Jake Bordenave, P.E.

November 5, 1991

Gilbert Aldaz, P.E. & P.S.
Civil Engineer/Hydrology

GRADING AND DRAINAGE PLAN - DETENTION POND ZANIOS FOODS

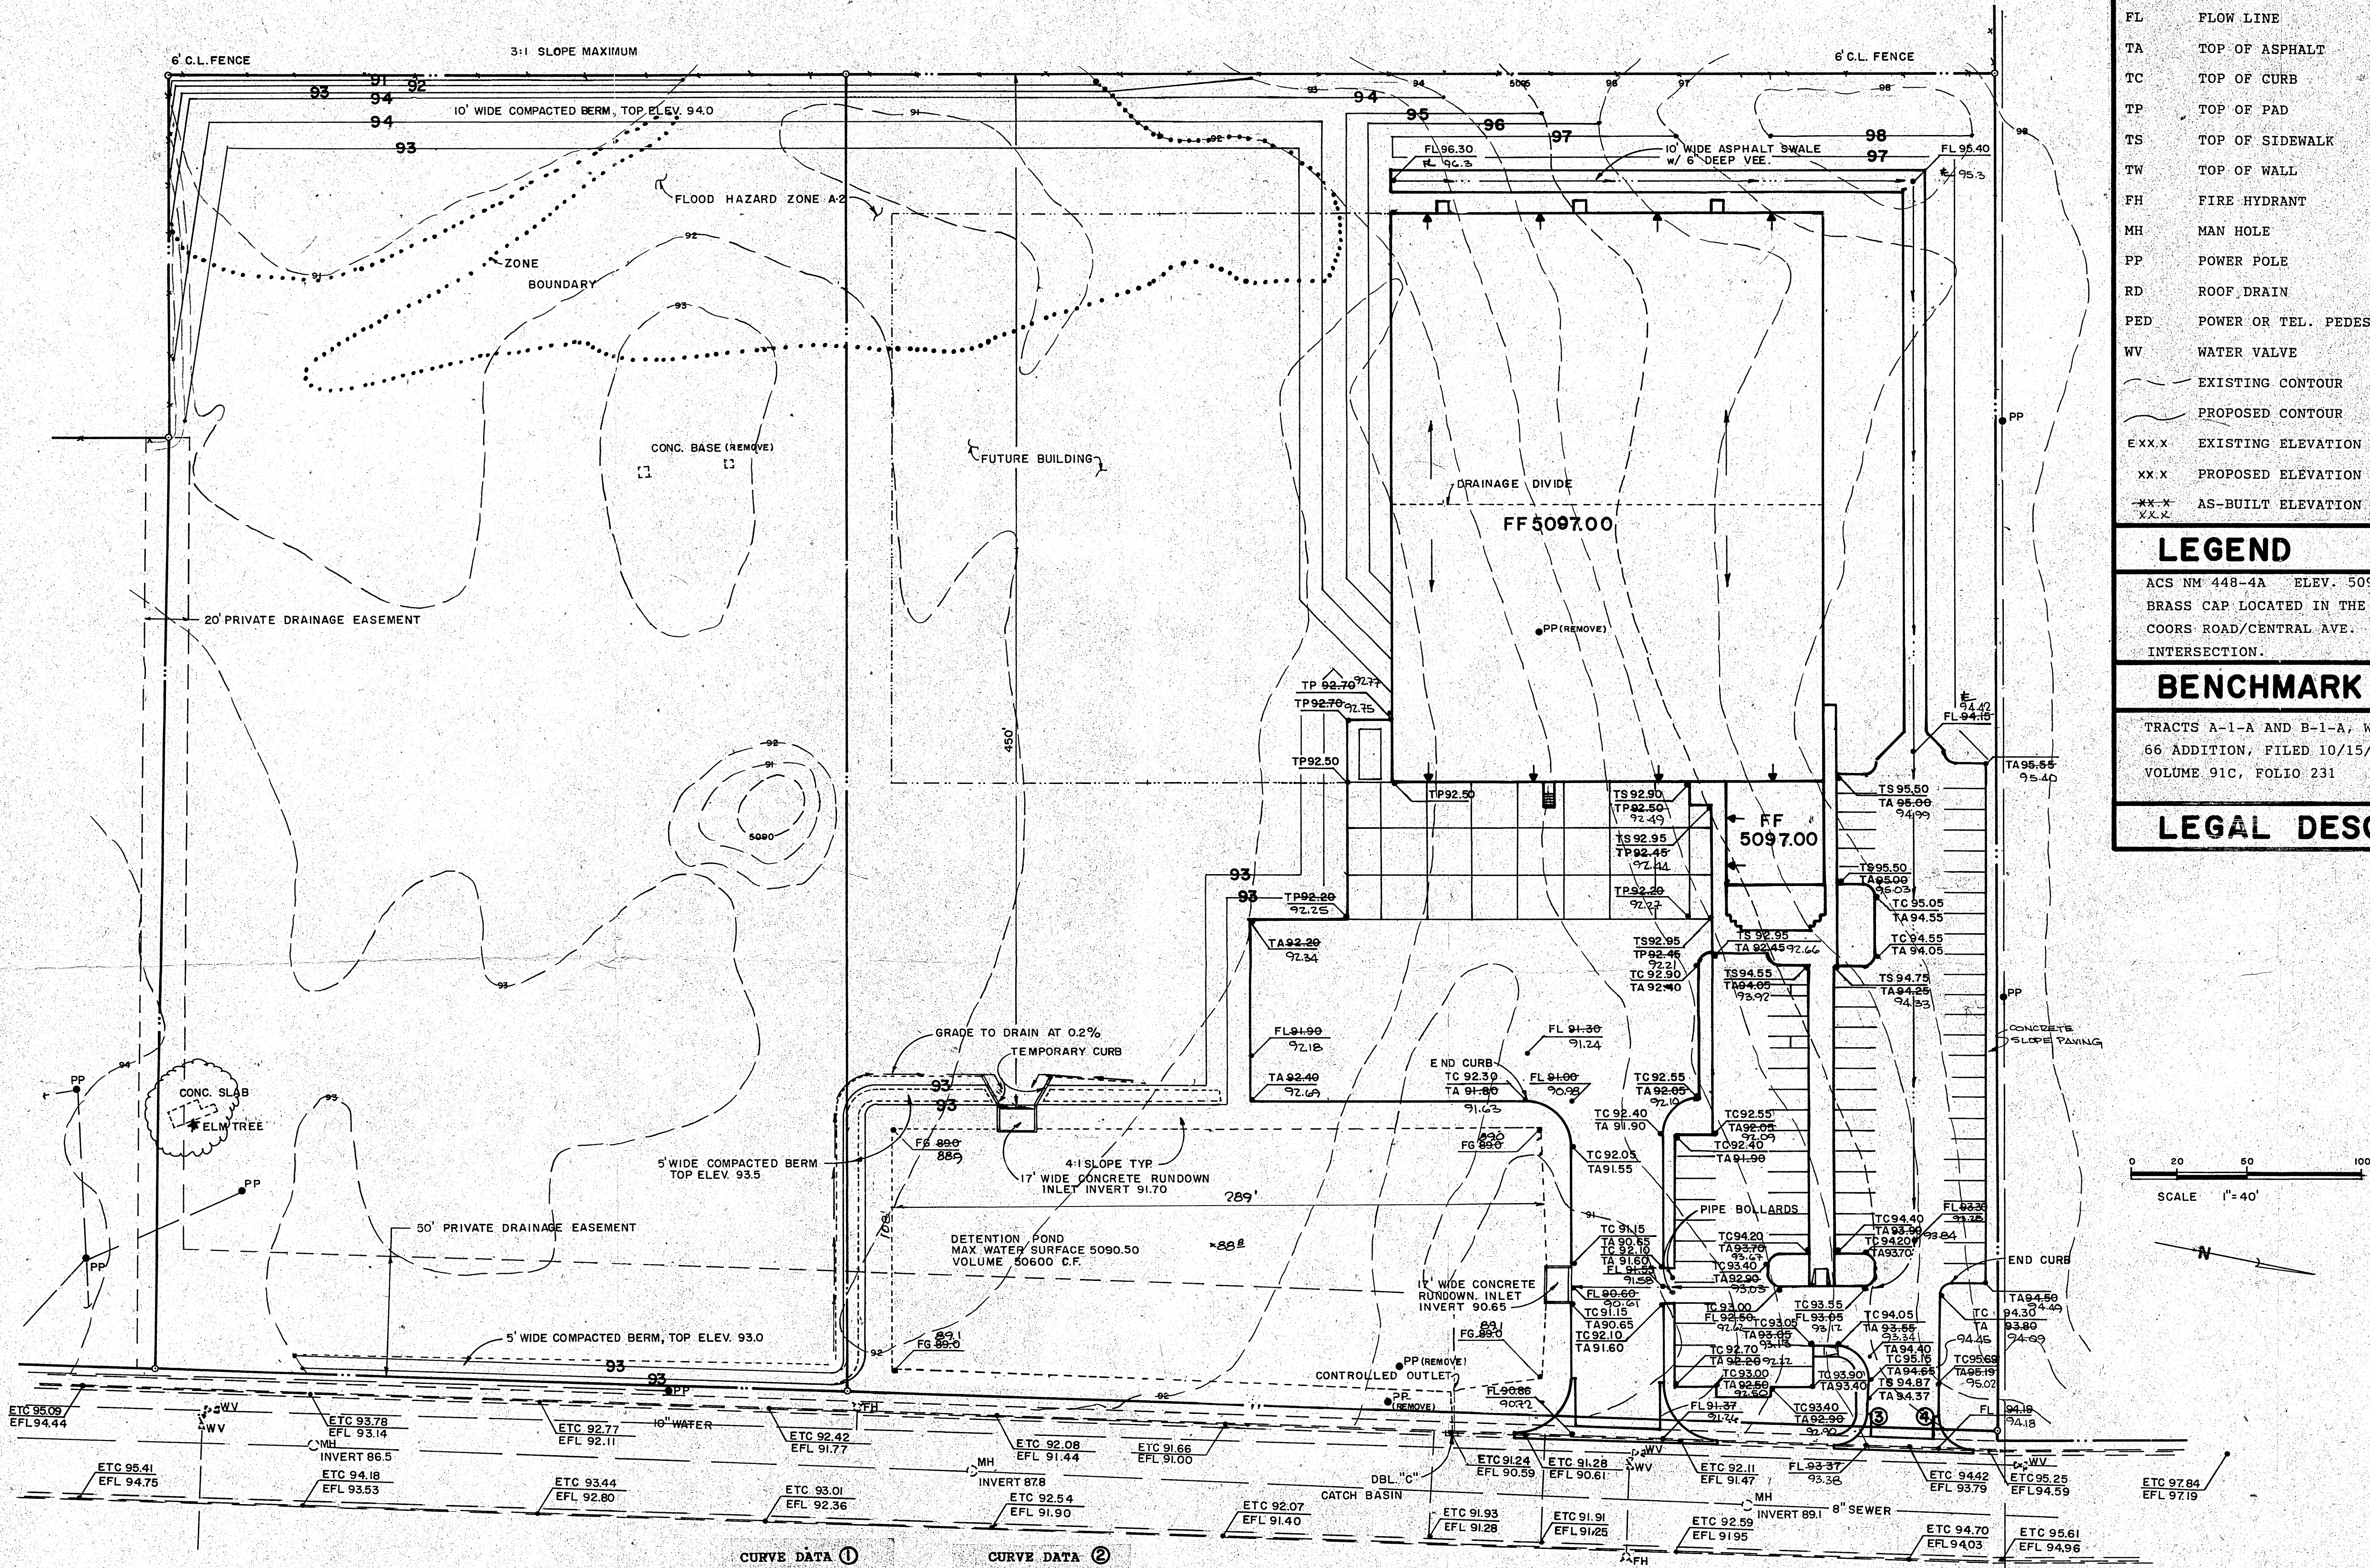
6. I cannot comment on your pond design at this time because I cannot separate out the phasing. I will comment on the pond design when phasing plans are received.
